Ribble Valley Borough Council
Housing & Development Control

Application no: **3/2023/0188**

Address: **Royal Oak Inn Waterloo Road Clitheroe BB7 1NS**

Proposal: **Proposed two storey side extension, single storey extension to side rear. Alterations to existing fenestration and change of use from A4 (Drinking Establishment) to Class E (Commercial, Business and Service).**

DRAWING TITLE
Existing and Proposed Plans

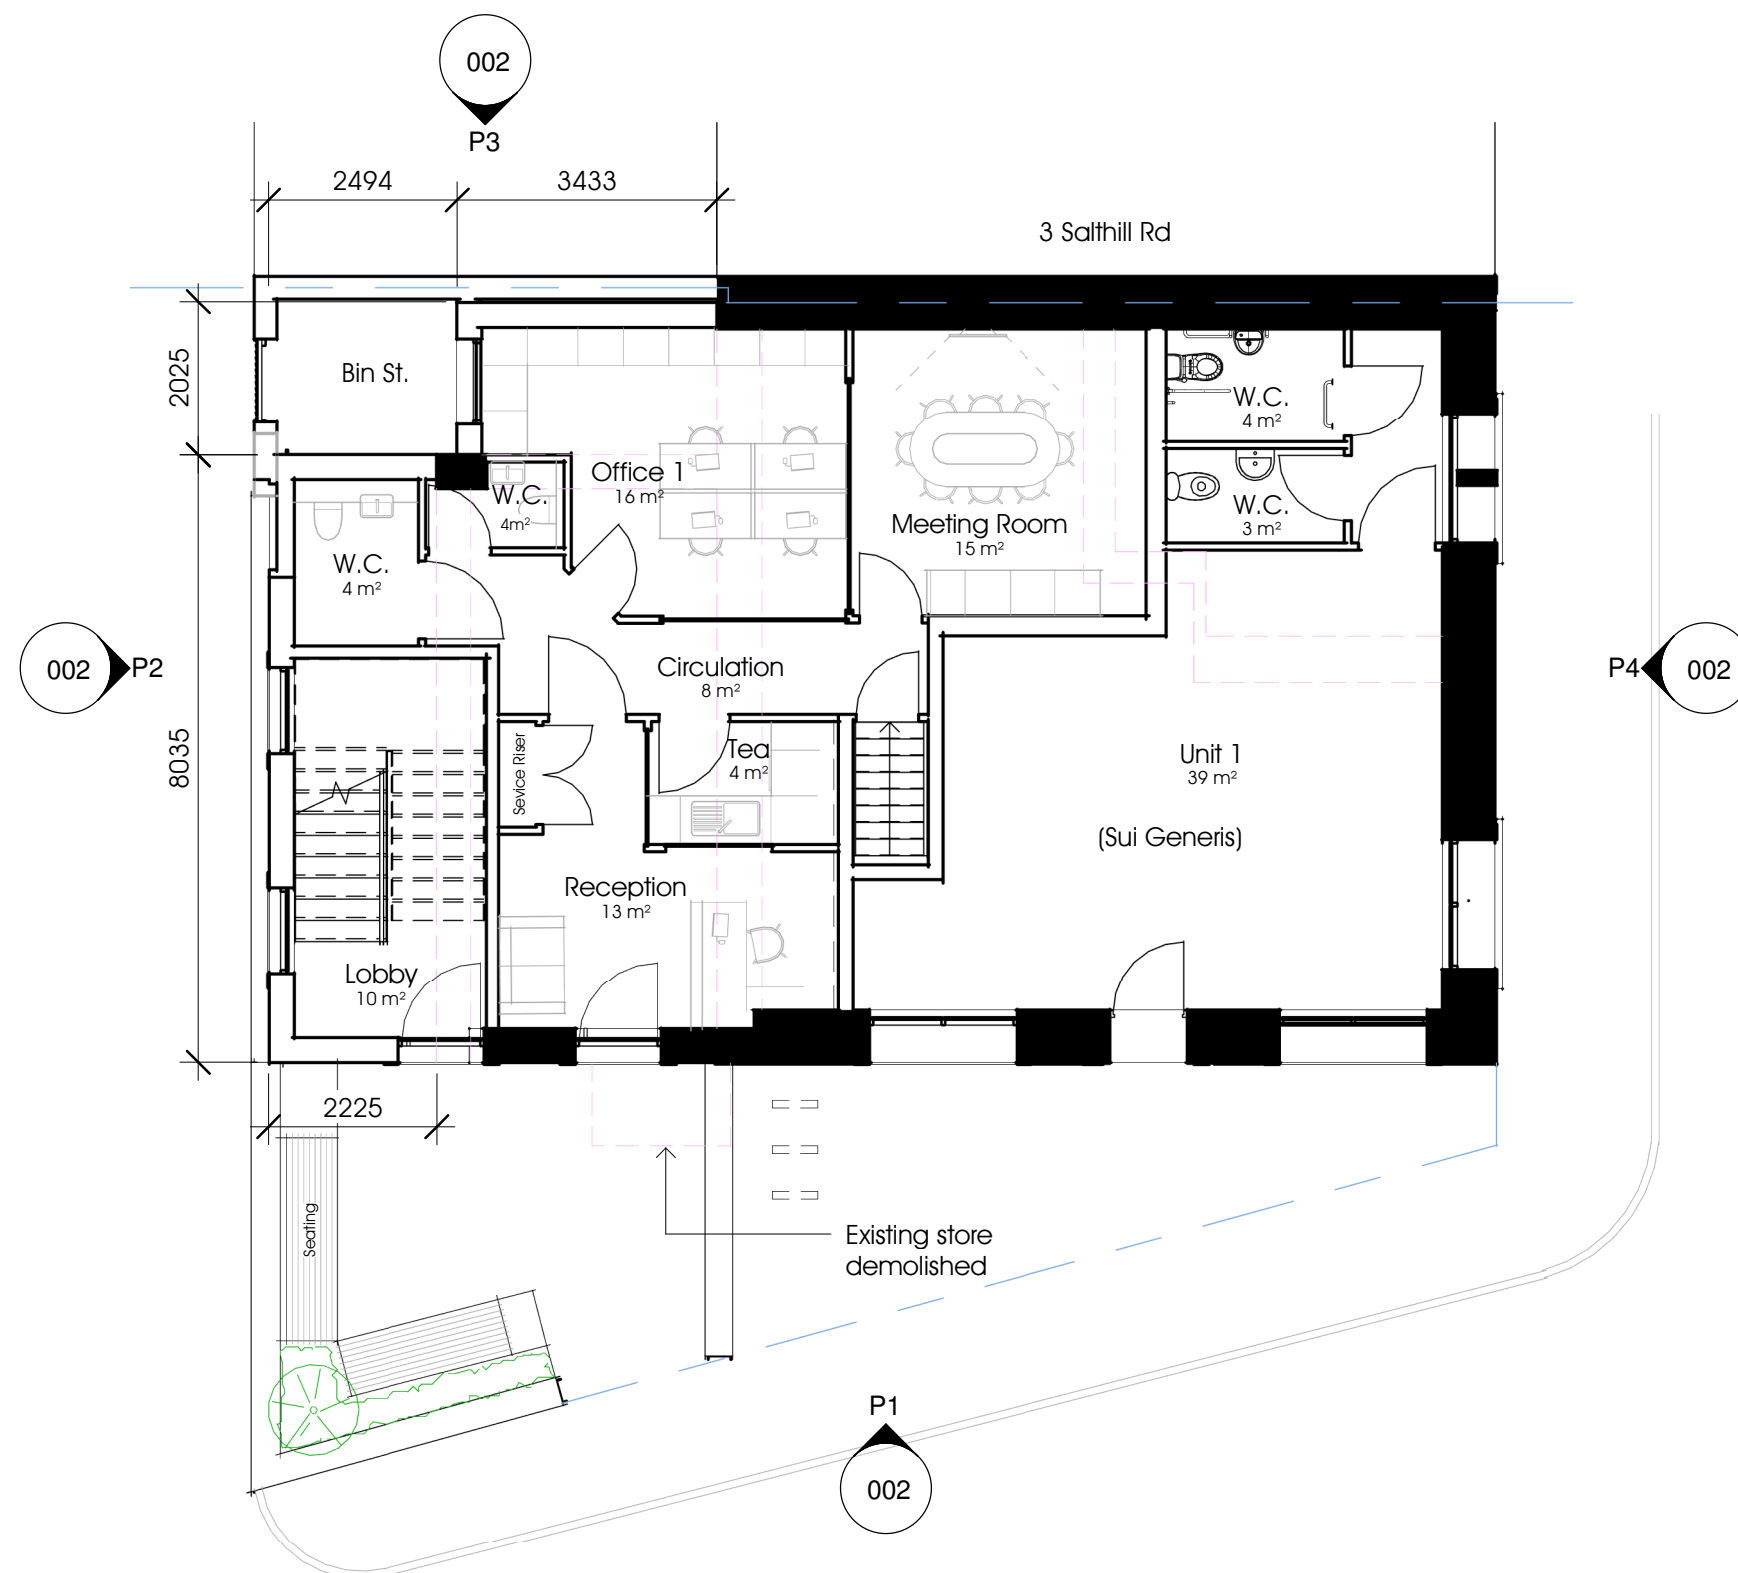
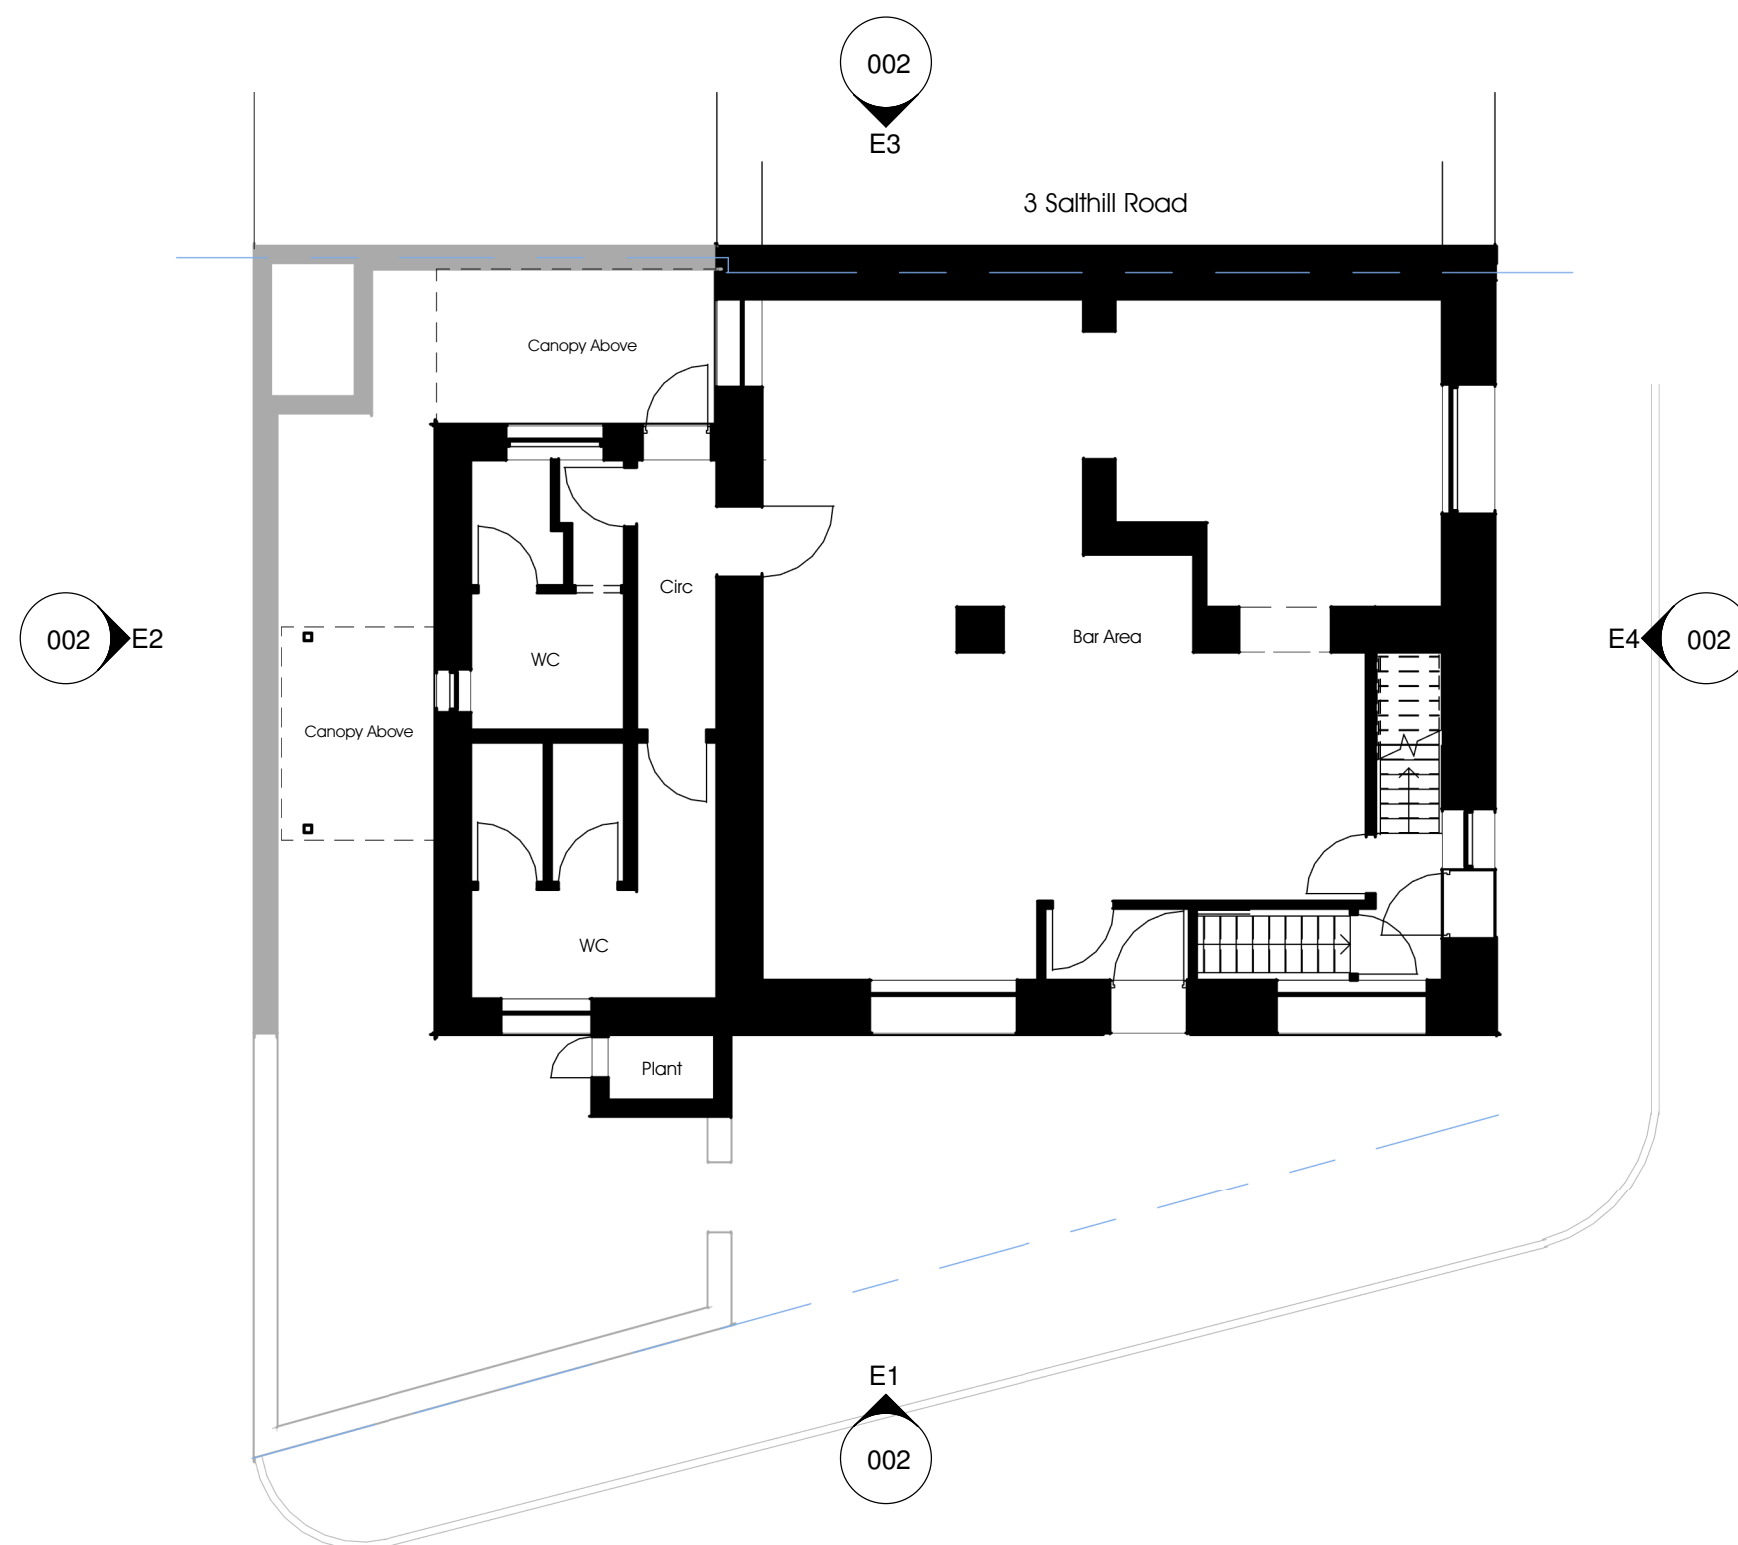
To encourage cycling to the site, the LHA will request that the provided cycle storage facilities, as shown on Aldrock drawing number 001 Rev A titled "Existing and Proposed Plans," are sheltered from the weather and secure for users. The LHA will also request that the area provides enough space for a minimum of 6 bicycles.

2. No building or use hereby permitted shall be occupied or the use commenced until a cycle storage plan for the commercial unit has been submitted to the Local Planning Authority, in consultation with the Local Highway Authority. These cycle facilities shall thereafter be kept free of obstruction and available for the parking of bicycles only at all times.
